MEMORANDUM

From: Kacey Simon, Civil Plan Reviewer

RE: 87th & 40th PRD, File# PA22-040
187 unit townhome development on fee simple lots
4218, 4112, 4018, 3992 87th Avenue NE & Parcel #'s 00590700021201 / 00590700021202 /
00590700021300 / 00590700022000 / 005907000236000

Date: 1/2/2024

ENTERING SIGHT DISTANCE EXHIBIT
87TH AND 40TH PRD
PNW INVESTORS, LLC
PO BOX 1930
WOODINVILLE, WA 98072

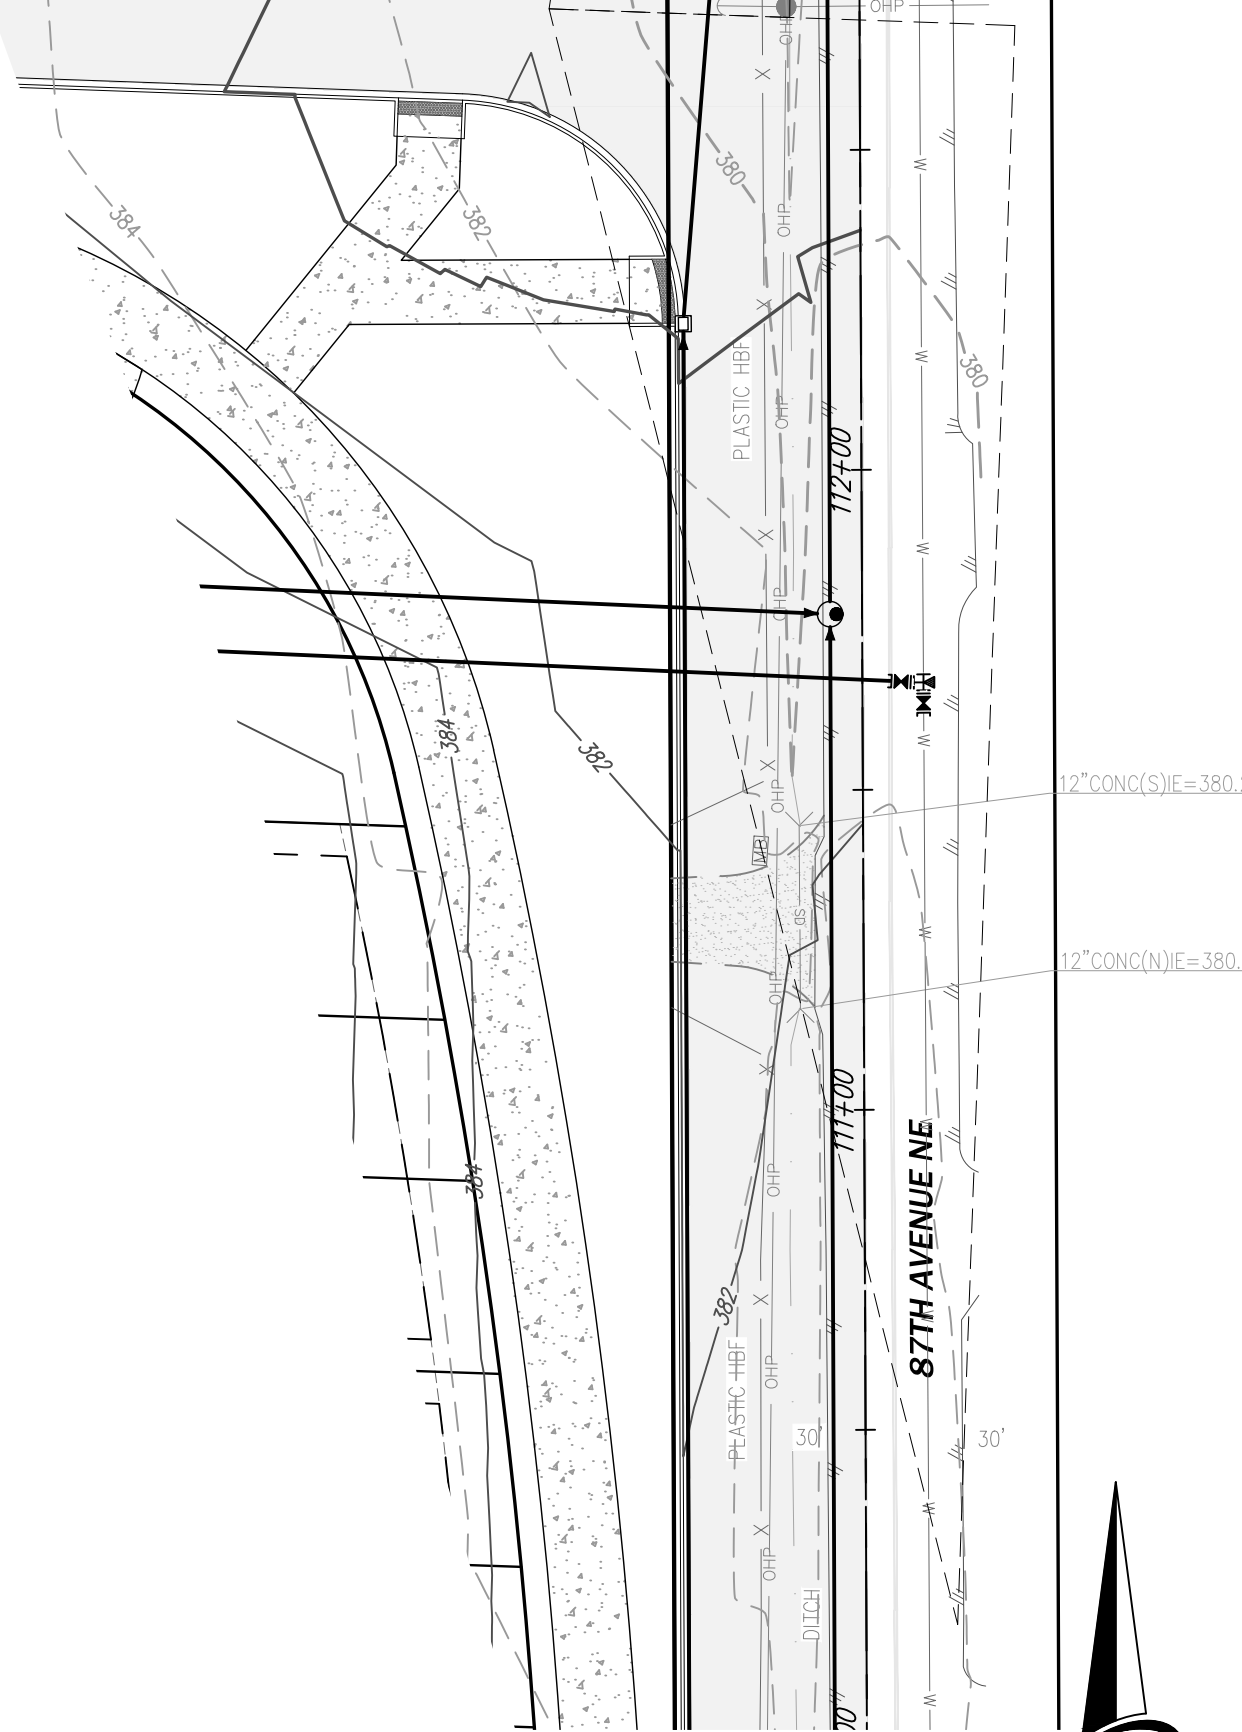
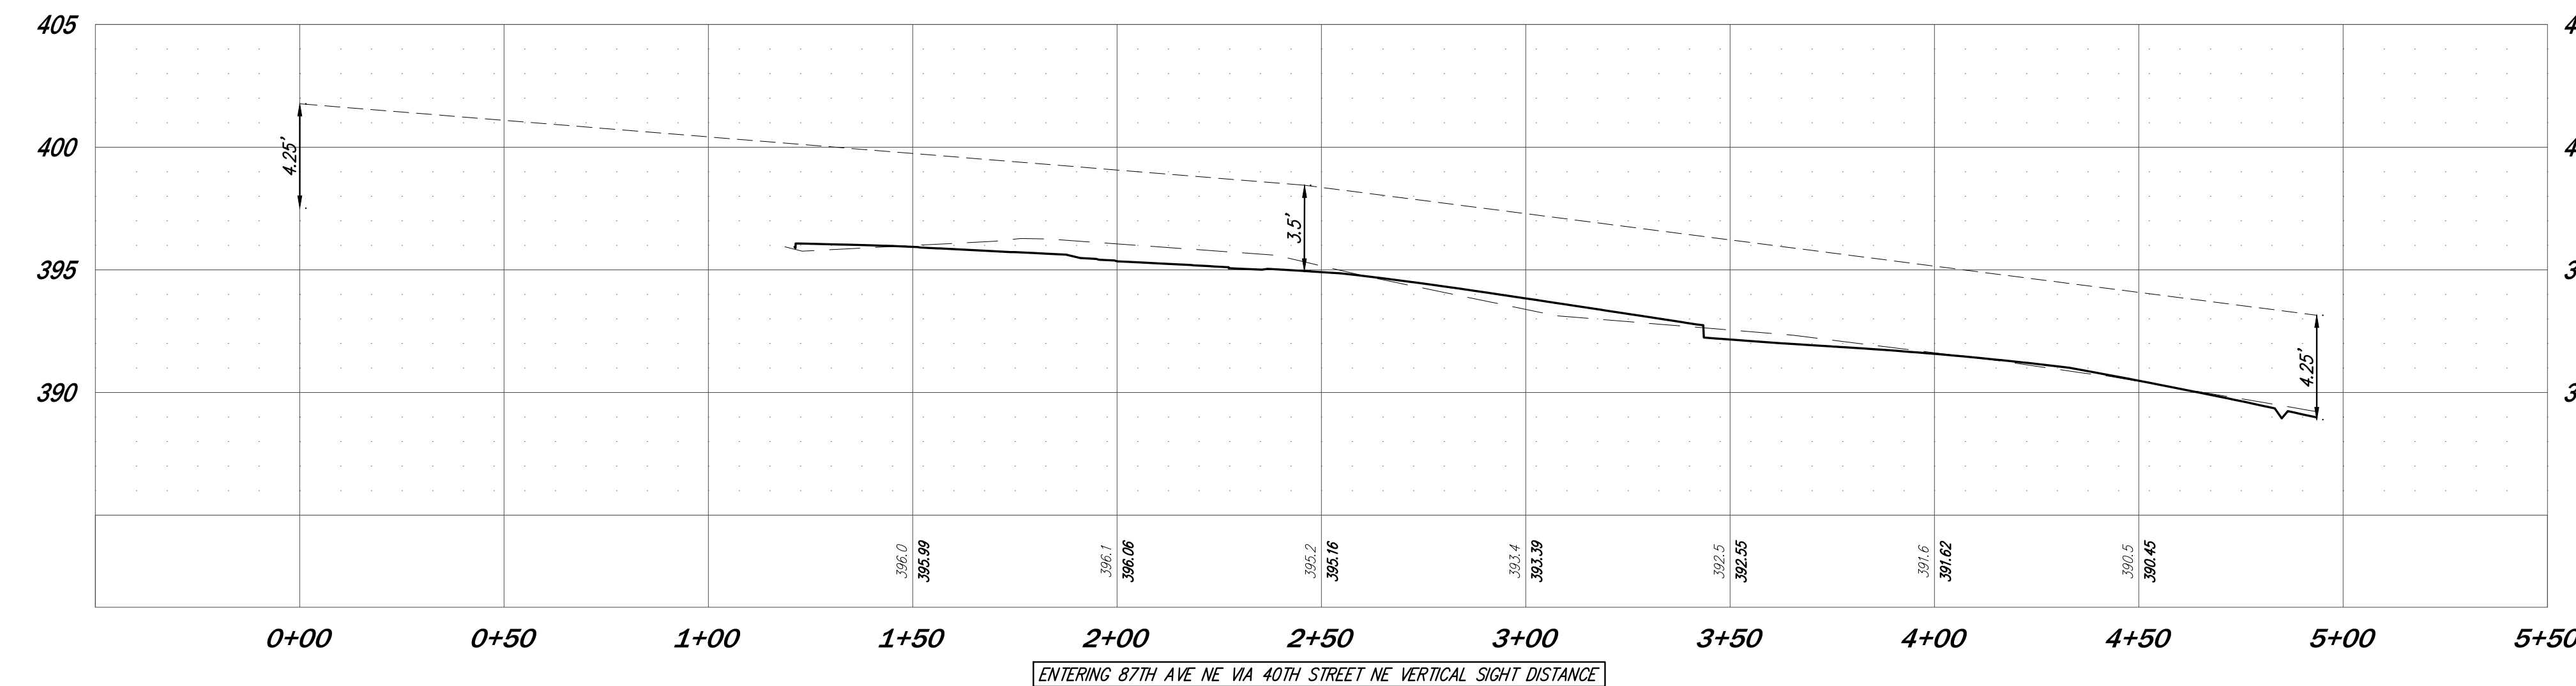
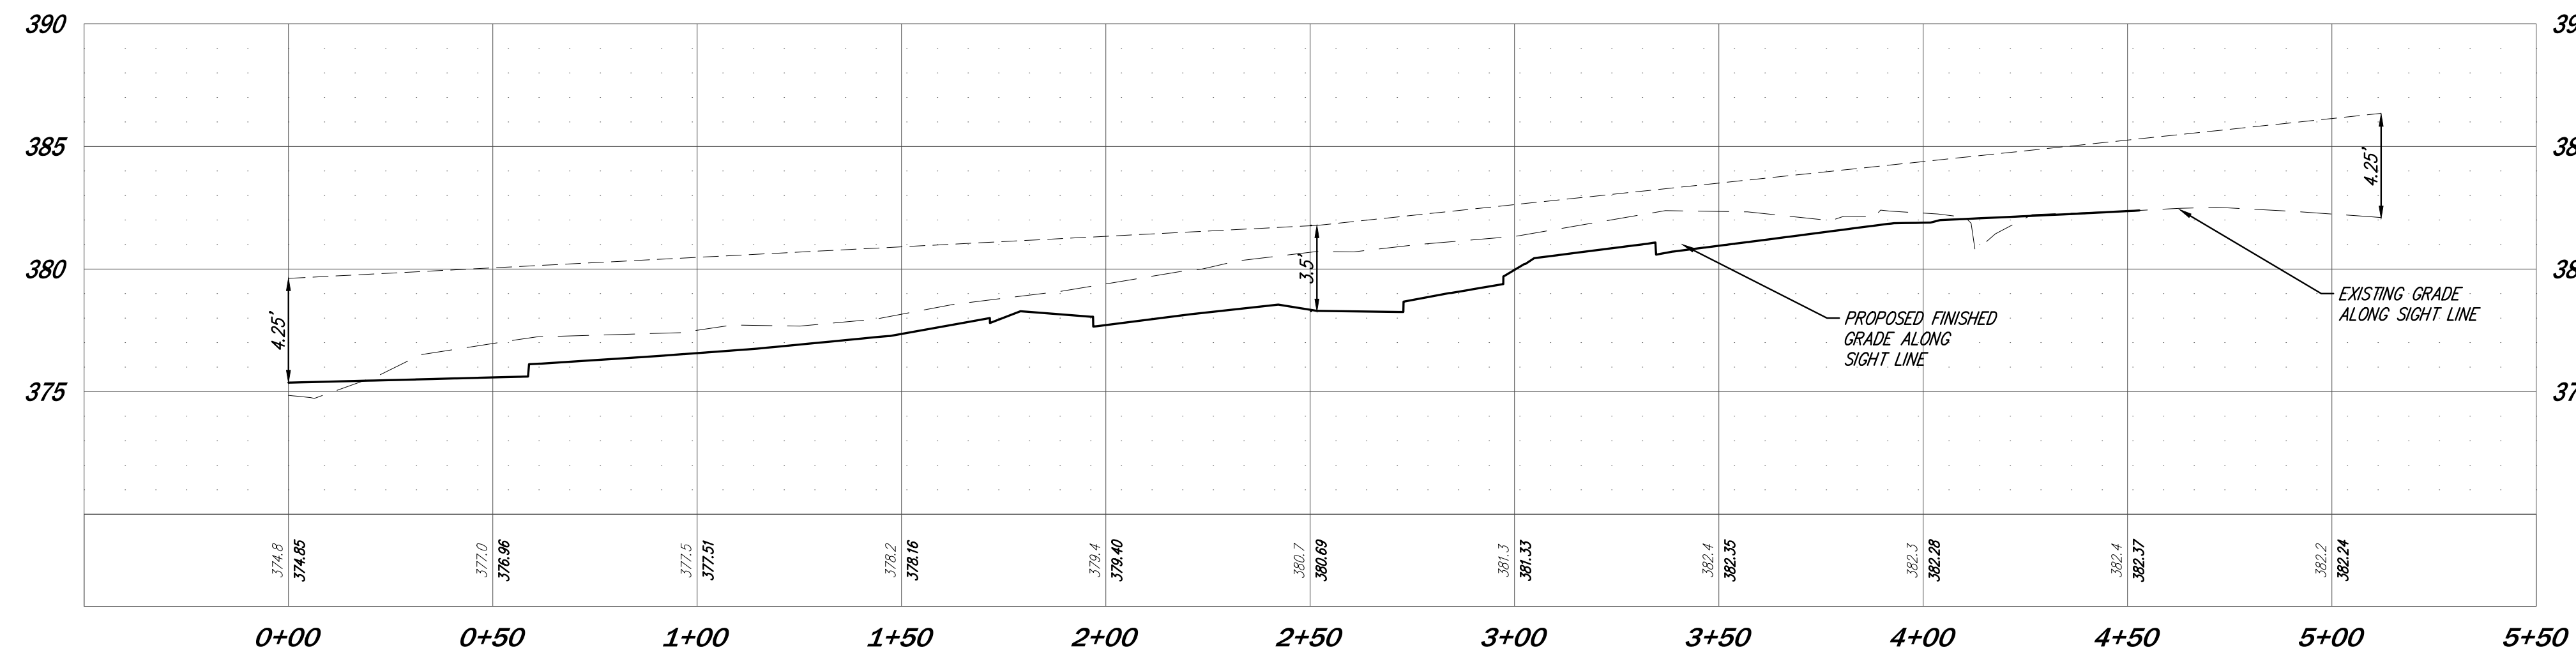
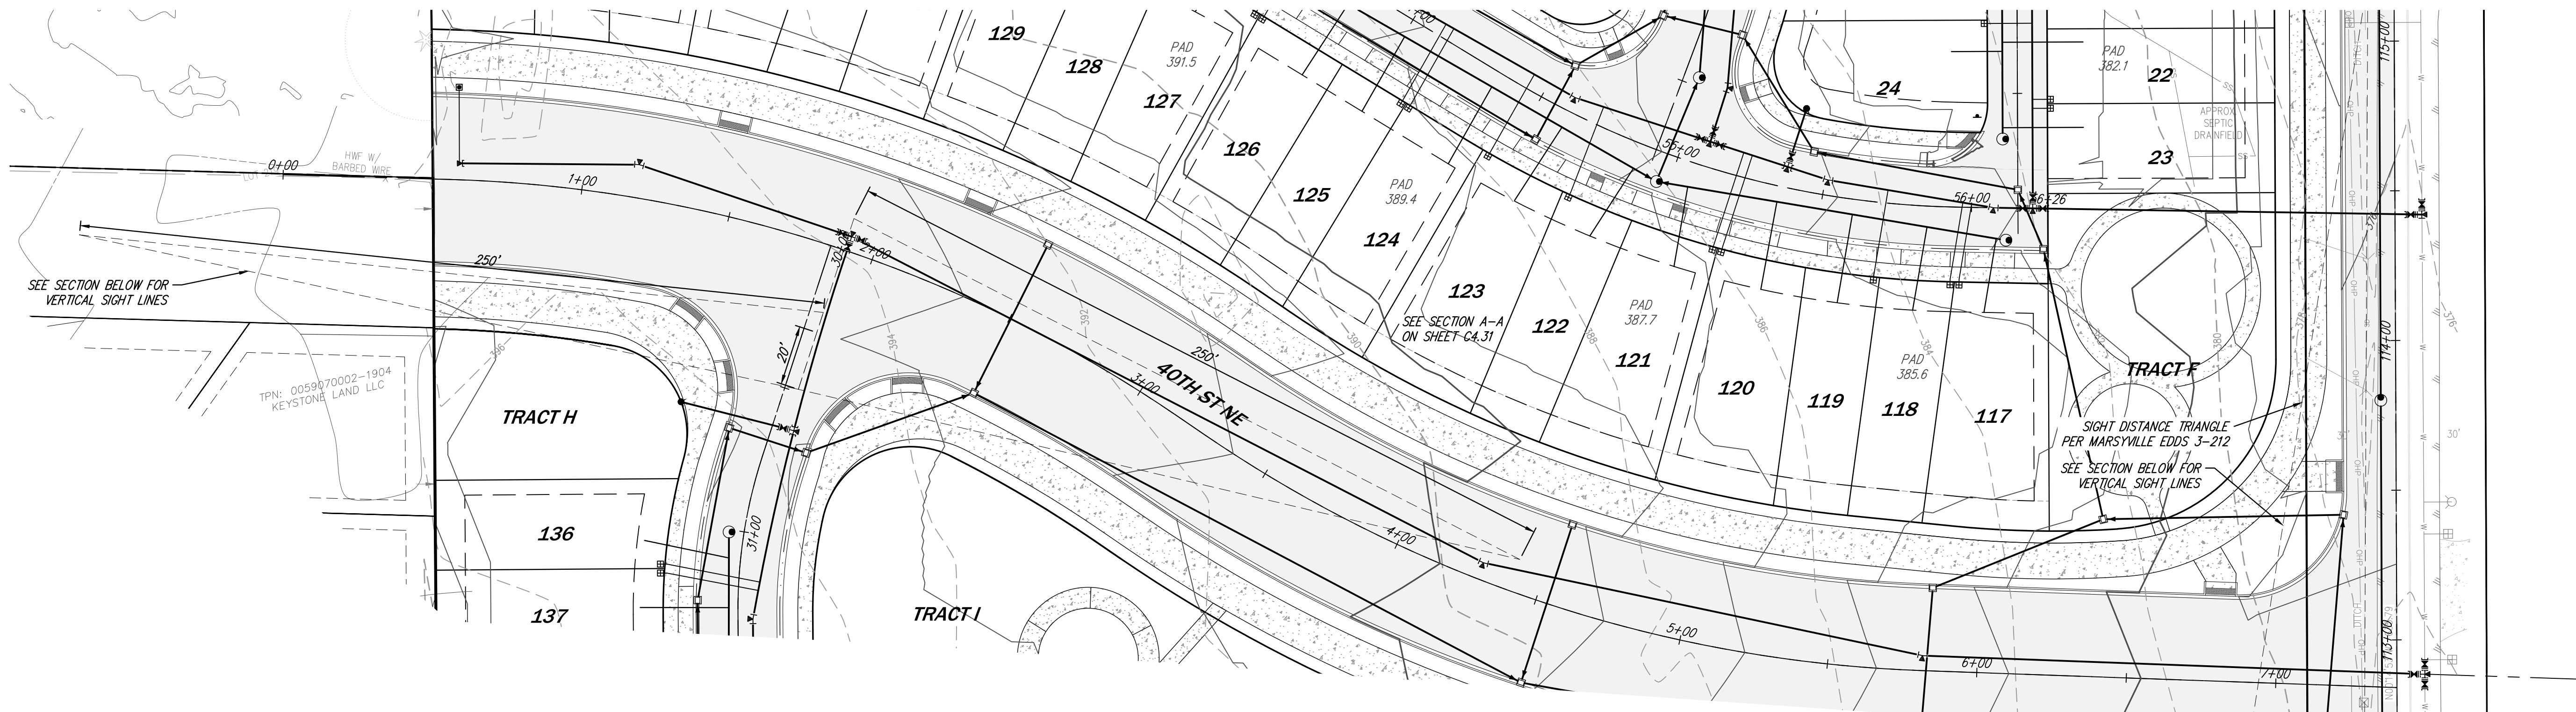
- a. TIA is acceptable.
- 3) Per EDDS 3-312, Intersection sight distance for both new roadways shall be evaluated.
 - a. Sight Distance shown on plans appears to be Stopping Sight Distance rather than Intersection Sight Distance.

- b. For 40th ST NE, roadway speed shall be assumed as 35 mph, not 25 mph.
 - c. Based upon information shown, it does not appear that sight distance is likely to be inadequate, however plan sheets shall be updated for confirmation of such based upon intersection sight distance with corrected speed limit.
